Additional Submission  
Relevant Representation 20050600  
On Behalf of Burn Gliding Club

Issue Specific Hearing 1 (ISH1)  
The principle and scope of the Proposed Development

Drawing Title **Cumulative Schemes**

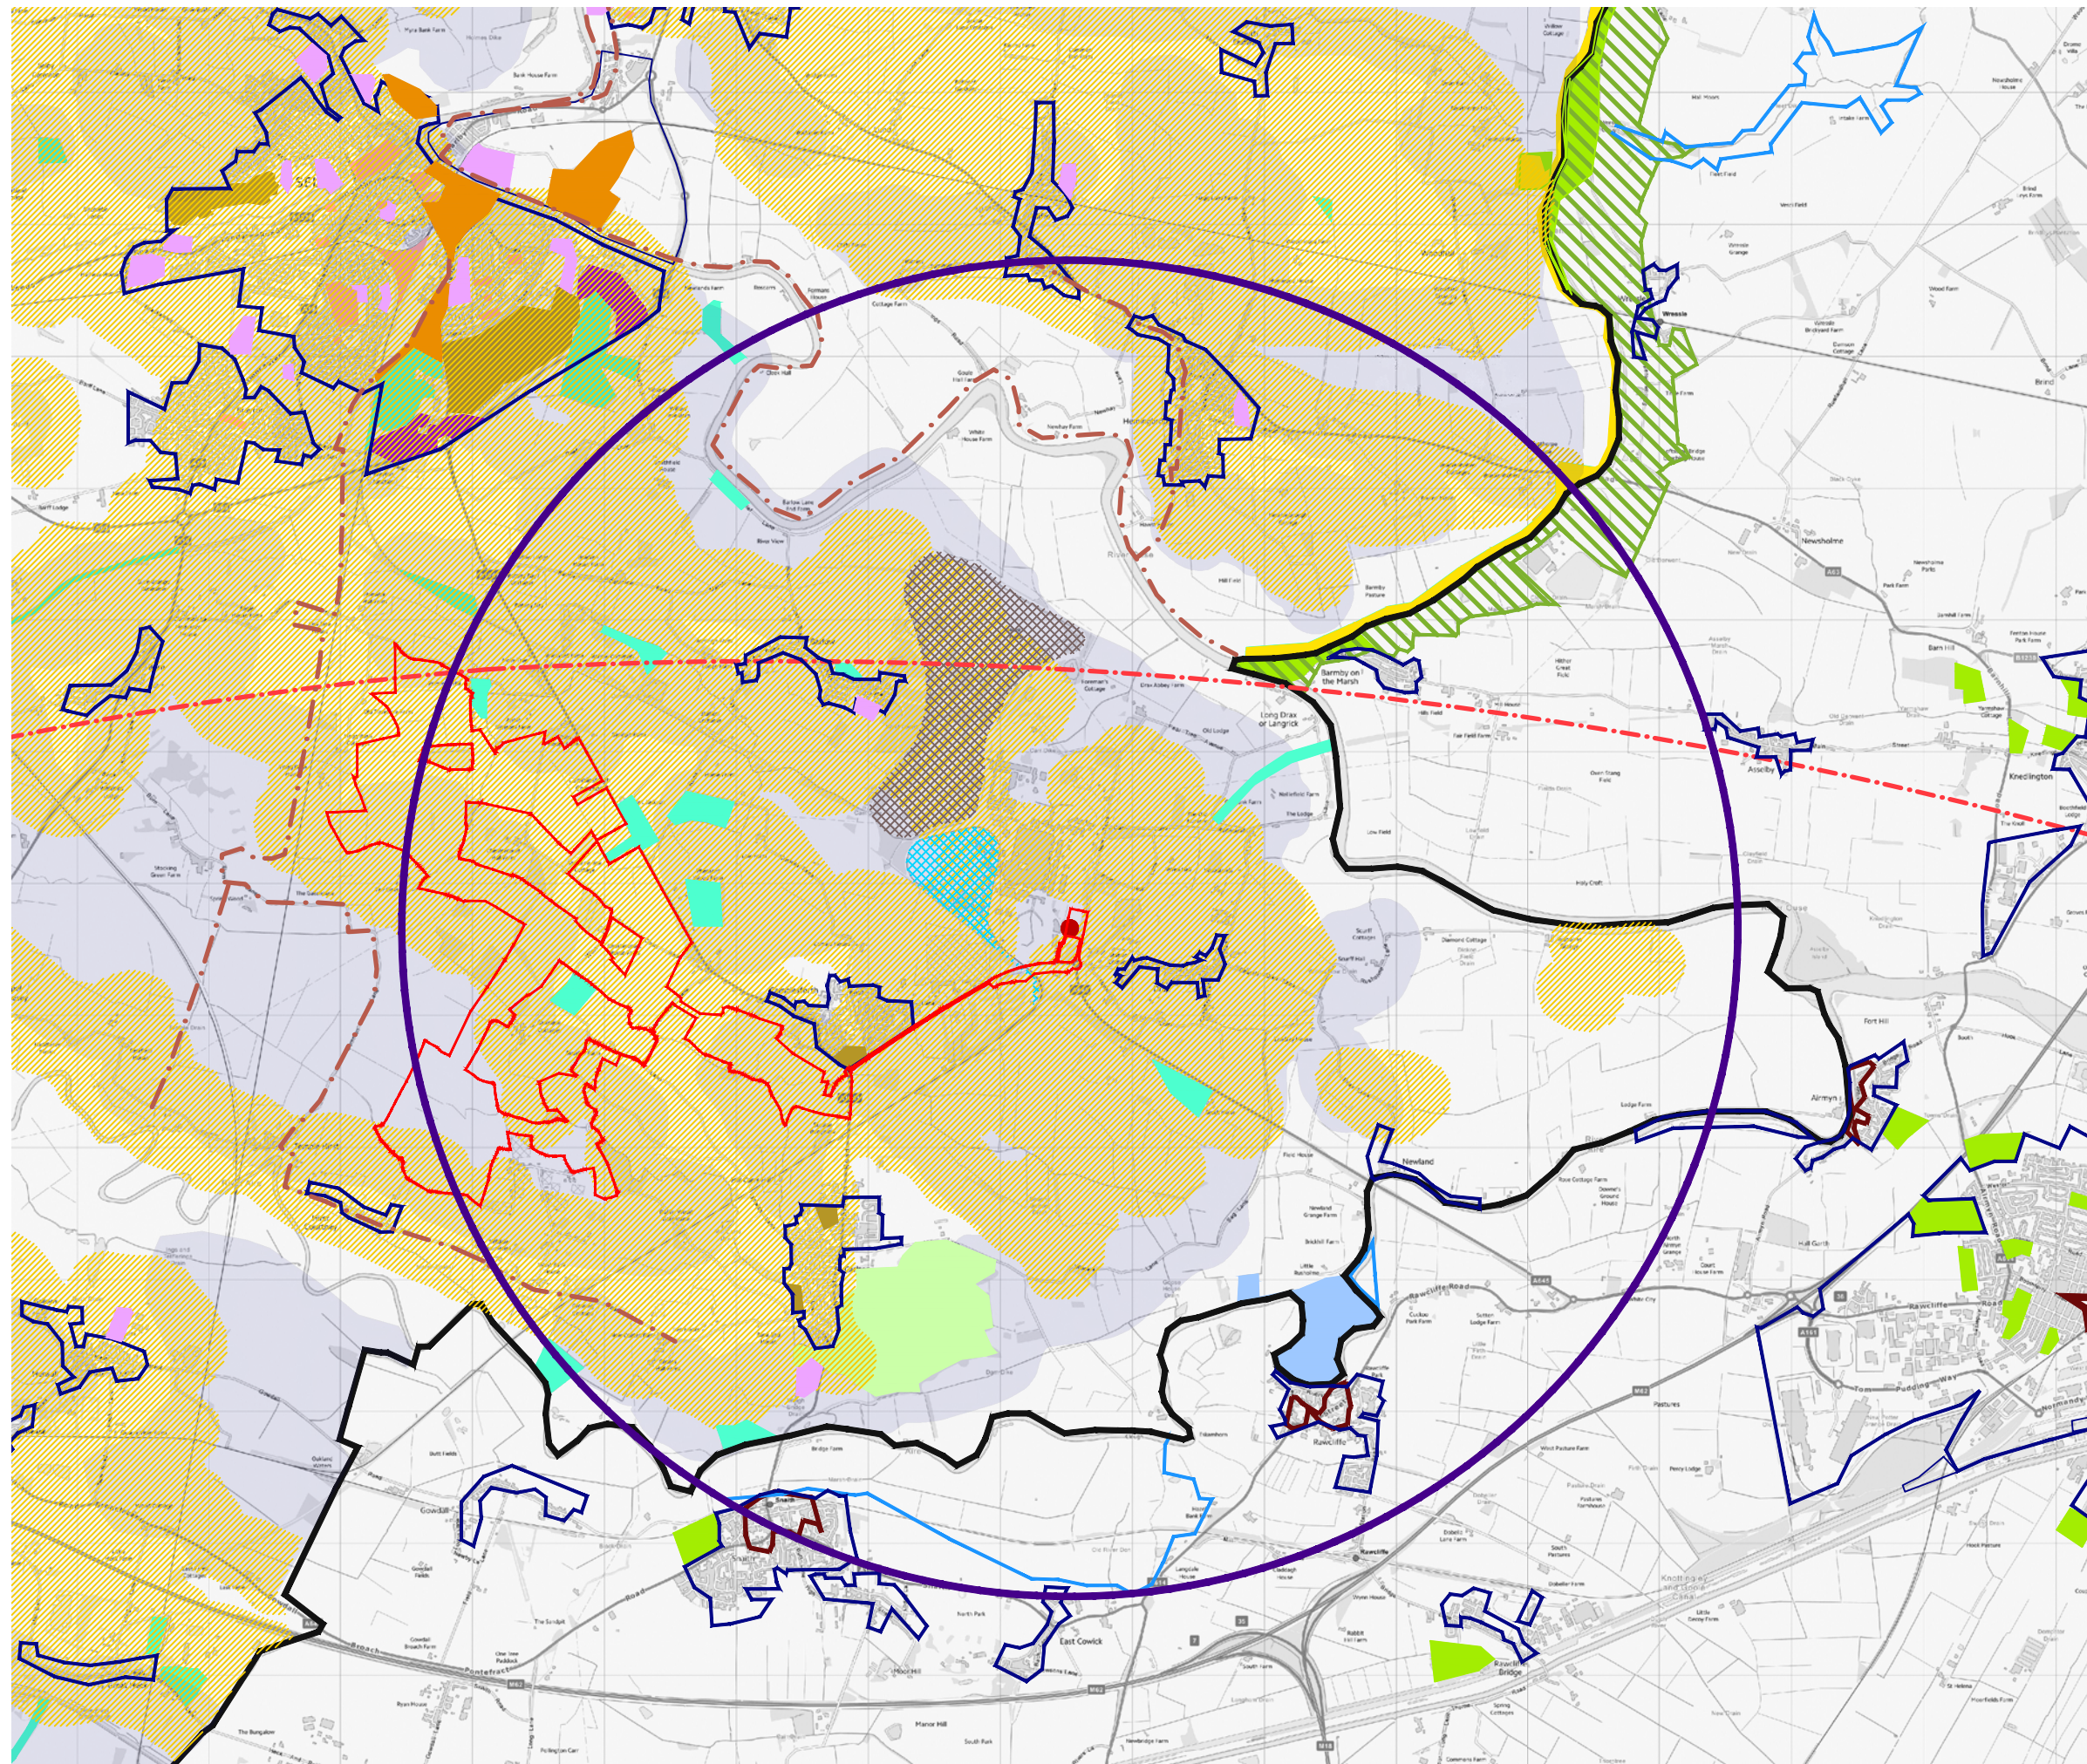
- c. Some other development schemes are shown on Figure 2.6 although this is out of date. For example, ref: 2022/10054 [which should have been either 1004 or 1005] /SCN is out of date. Planning permission was granted for this scheme by application reference number 2023/0128/EIA on 17 April 2024.
